AKD/KT
14448
10 August 2016

**SECTION 96(1A) - MODIFICATION APPLICATION TO SSD 6952
WENONA SCHOOL**

On behalf of Wenona School Limited, we hereby submit an application pursuant to section 96(1A) of the *Environmental Planning and Assessment Act, 1979* (EP&A Act) to modify Development Consent SSD 6952 relating to the approval of a new educational facility at Wenona School, North Sydney.

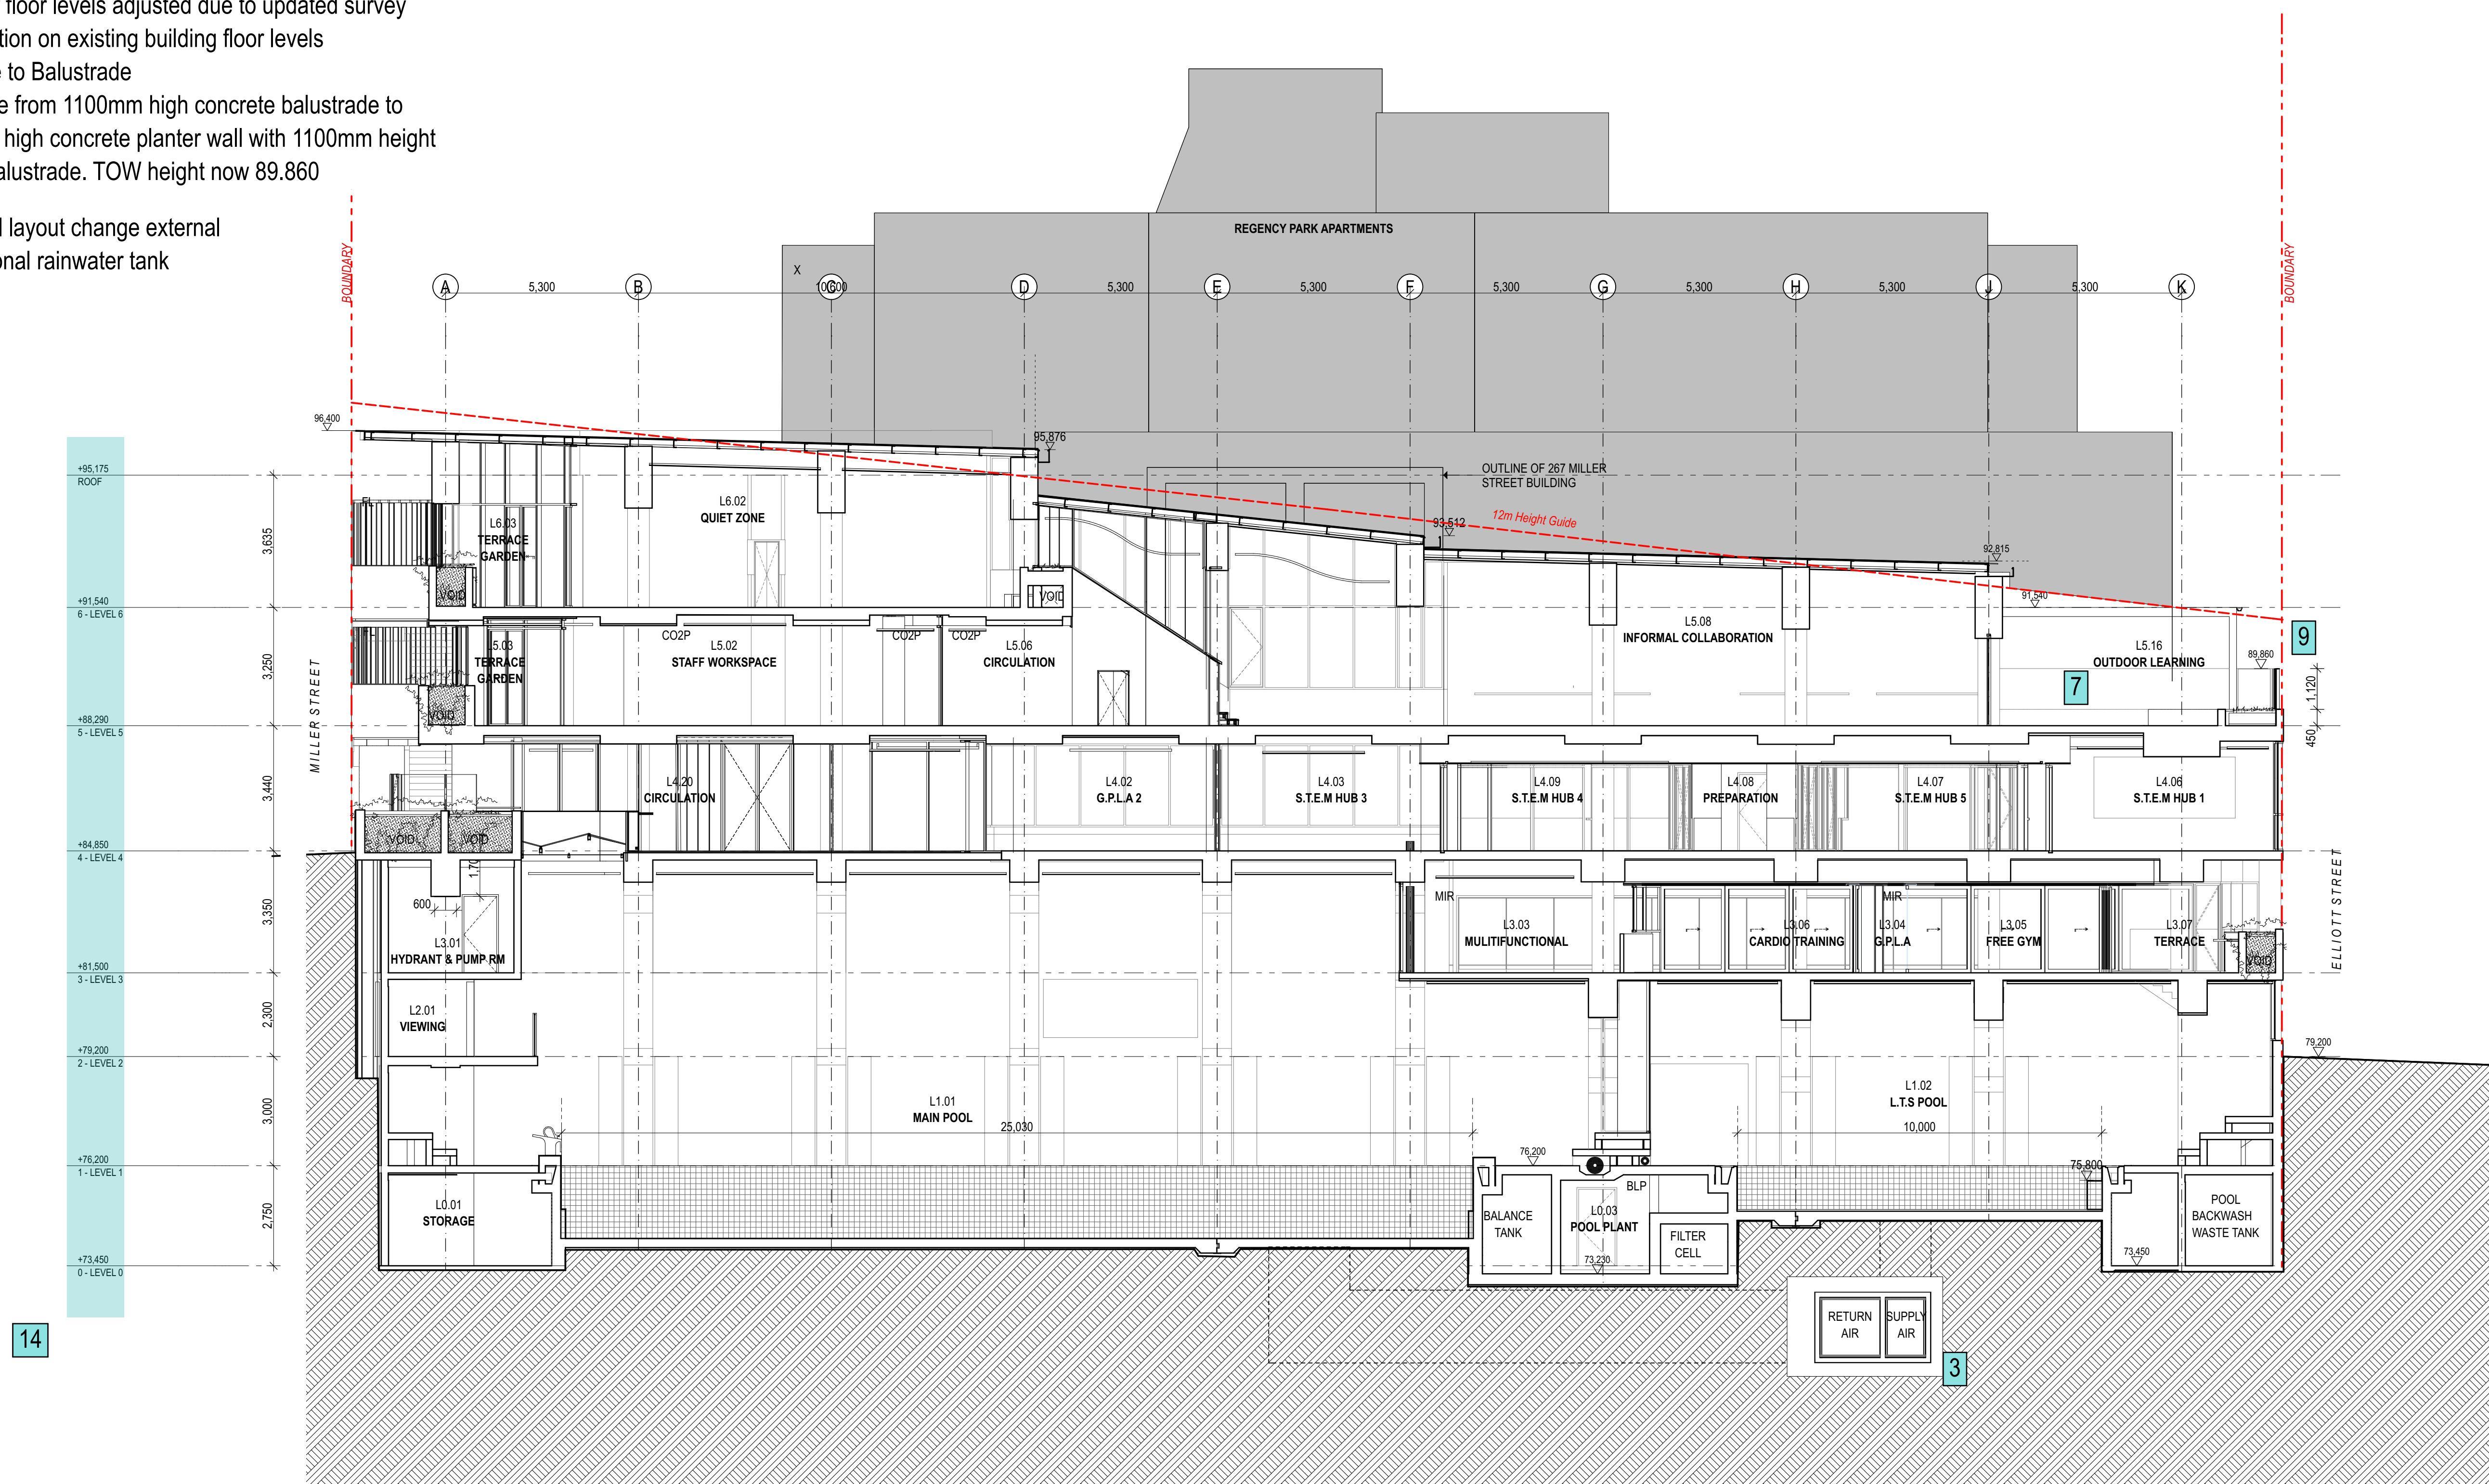
Elevation North	<ul style="list-style-type: none"> minor correction of RLs of the floor to floor levels in response to survey details; conversion of the concrete balustrade fronting the Elliott Street to a concrete planter wall with glass balustrade with a total height of 1570mm; and provision of a small area of additional roofing to weatherproof between the existing and new buildings at the roof line. 	A – 2003	A
Section AA	<ul style="list-style-type: none"> increase to the extent of the mechanical trenching; minor correction of RLs of the floor to floor levels in response to survey details; conversion of the concrete balustrade fronting the Elliott Street to a concrete planter wall with glass balustrade with a total height of 1570mm; and installation of a rainwater tank on the Level 5 terrace. 	A – 3000	A
Section B-B, C-C	<ul style="list-style-type: none"> minor correction of RLs of the floor to floor levels in response to survey details; provision of a small area of additional roofing to weatherproof between the existing and new buildings at the roof line; change to the materiality of the southern side of the bridge; increase to the extent of the mechanical trenching; and boundary adjustment to reflect the alignment of the bridge. 	A – 3001	A

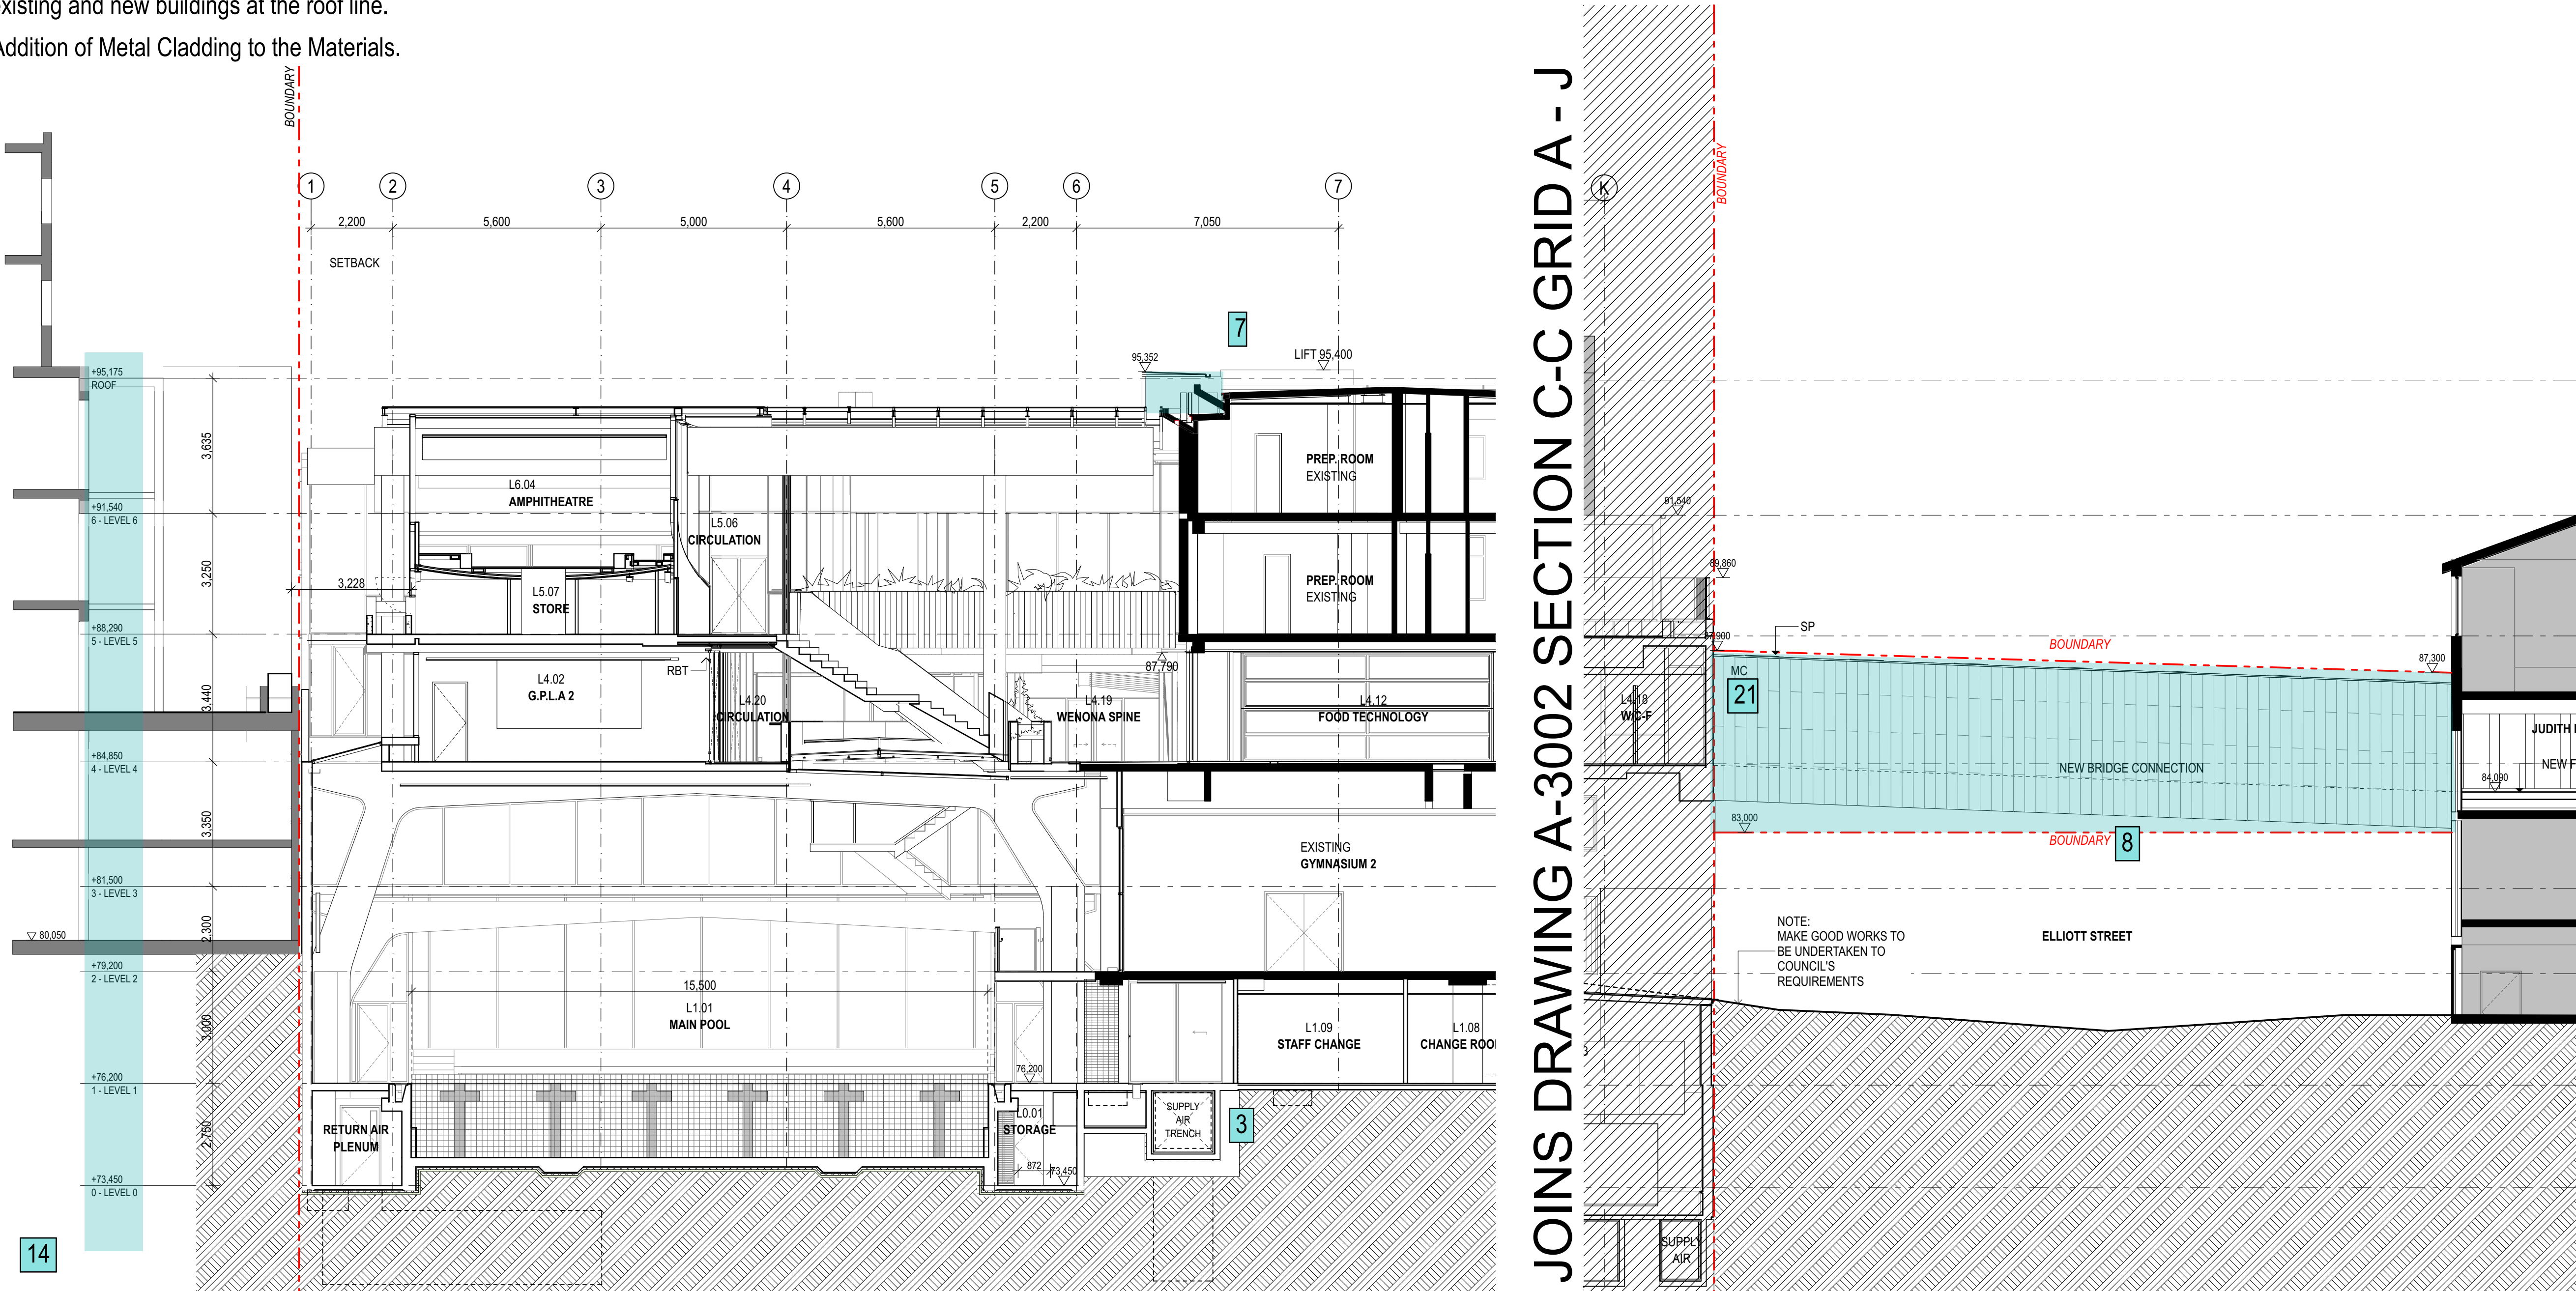
Section CC	<ul style="list-style-type: none"> minor correction of RLs of the floor to floor levels in response to survey details; provision of a small area of additional roofing to weatherproof between the existing and new buildings at the roof line; relocation of kitchen exhaust; increase to the extent of the mechanical trenching; and increase to the extent of the louvres. 	A – 3002	A
